STATE OF NORTH CAROLINA
DEPARTMENT OF TRANSPORTATION

November 21, 2014

SUBJECT: **Request for Modification to the Section 404 Individual Permit and Section 401 Water Quality Certification** for the proposed Greensboro Eastern Loop from US 70 Relocation to SR 2303 (Lawndale Drive), Guilford County, Division 7. WBS Element No. 34821.1.1, TIP Nos. U-2525B and U-2525C.

**PERMIT DRAWINGS
SHEET 36 OF 93**

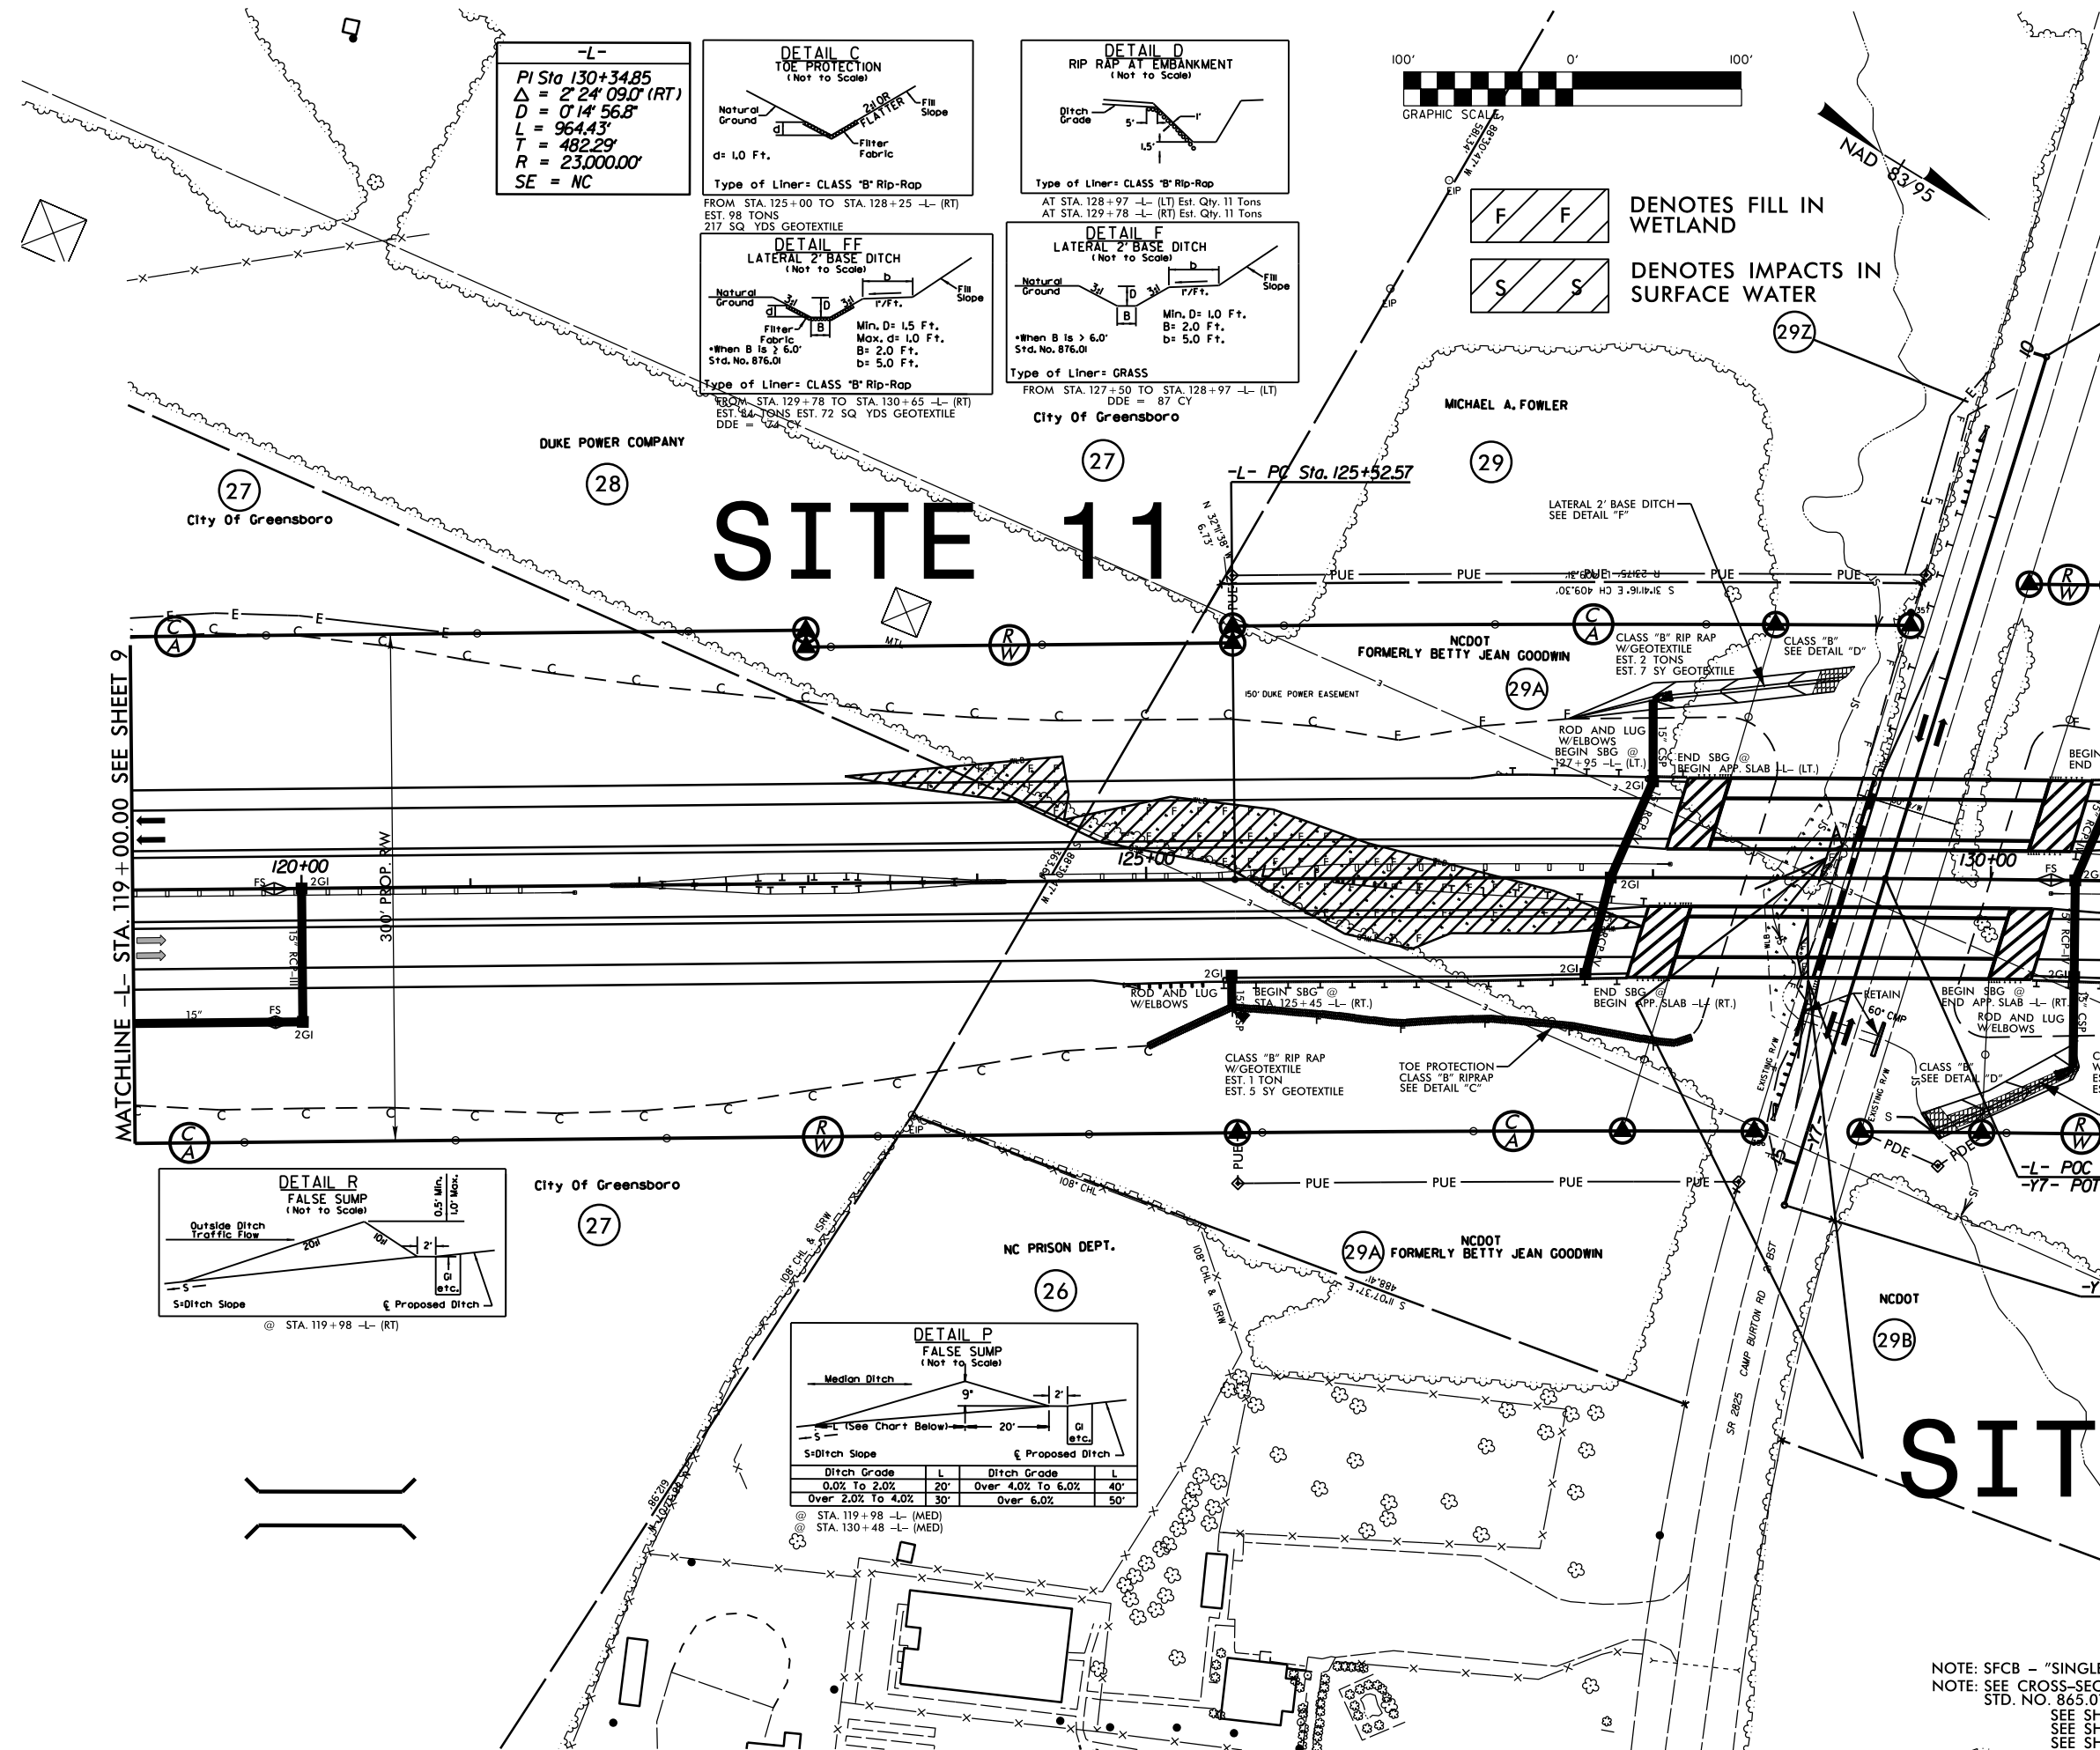
The area of new impacts (Permit Site 11A) was overlooked prior to the original permit application submittal. The wetland impacts for Permit Site 11A include <0.01 acre of permanent fill of Class II rip-rap for the proposed bridge bent protection (Table 1). Please replace the current permit drawings with the new revised drawings (Revised Permit Drawing Sheets 1, 36, 37, 89, and 93 of 93), all attached with this letter.
